WEST SUSSEX COUNTY COUNCIL CONSULTATION

TO:	Arun District Council FAO:Louise Shaw
FROM:	WSCC - Highways Authority
DATE:	2 August 2022
LOCATION:	Land rear of Oakhurst House and Huntington House West Drive Angmering
SUBJECT:	A/102/22/PL 1 No new dwelling. This application is a Departure from the Development Plan and is in CIL Zone 3 and is CIL Liable as new dwelling.
DATE OF SITE VISIT:	n/a
RECOMMENDATION:	Advice
S106 CONTRIBUTION TOTAL:	n/a

SITE LAYOUT PLAN AS PROPOSED

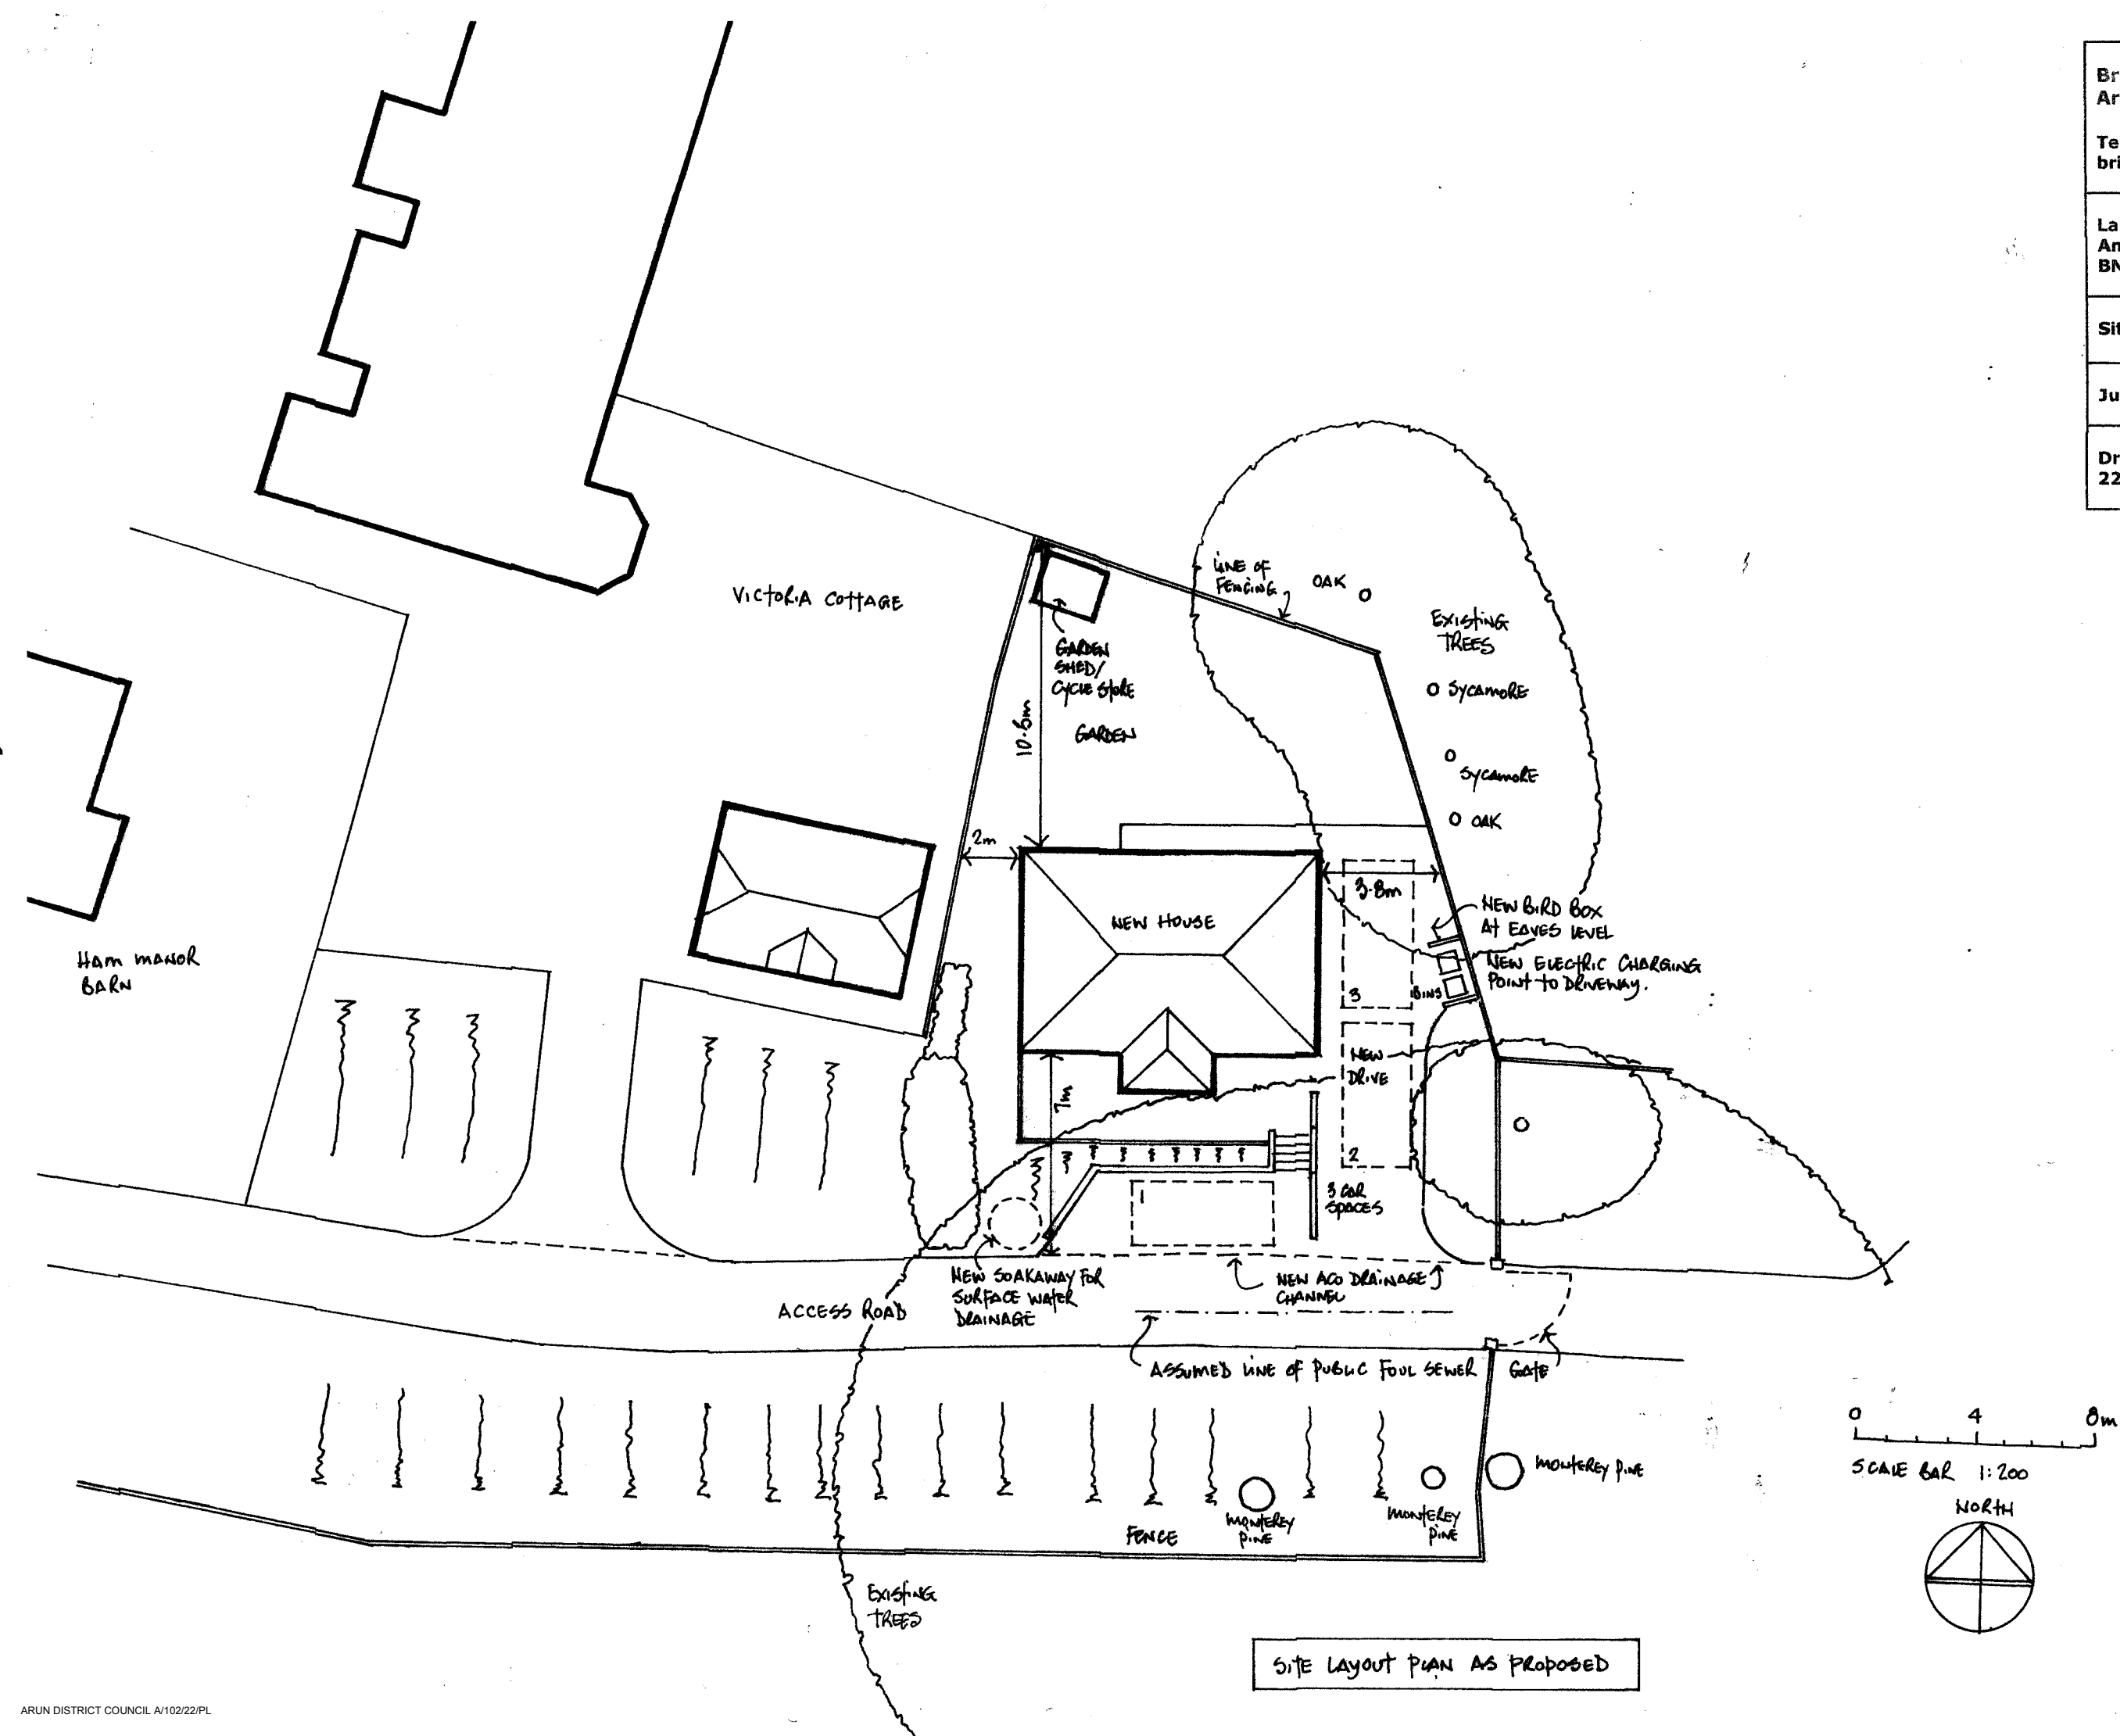
The proposed parking provision for the new dwelling will provide 3 parking spaces. Parking bays 1 and 2 measure circa 2.4 x 4.8m each and comply with the minimum requirements as outlined in Manual for Streets (MfS) guidance. Parallel parked bay number 3 measures slightly short of the minimum required width, however these seems to be sufficient space for enlargement. The WSCC Car Parking Demand Calculator (PDC) would expect 3 parking spaces to be provided for dwelling of this size and location.

Due to the location of the site in a position remote of shops and amenities, the LHA acknowledge that there will be the reliance on the use of a car for the majority of trips generated by the site. Secure and covered cycle parking has been provided to the rear of the dwelling and these details are acceptable.

No part of the development shall be first occupied until the car parking has been constructed in accordance with the approved site plan. These spaces shall thereafter be retained at all times for their designated purpose.

No part of the development shall be first occupied until covered and secure cycle parking spaces have been provided in accordance with the approved site plan.
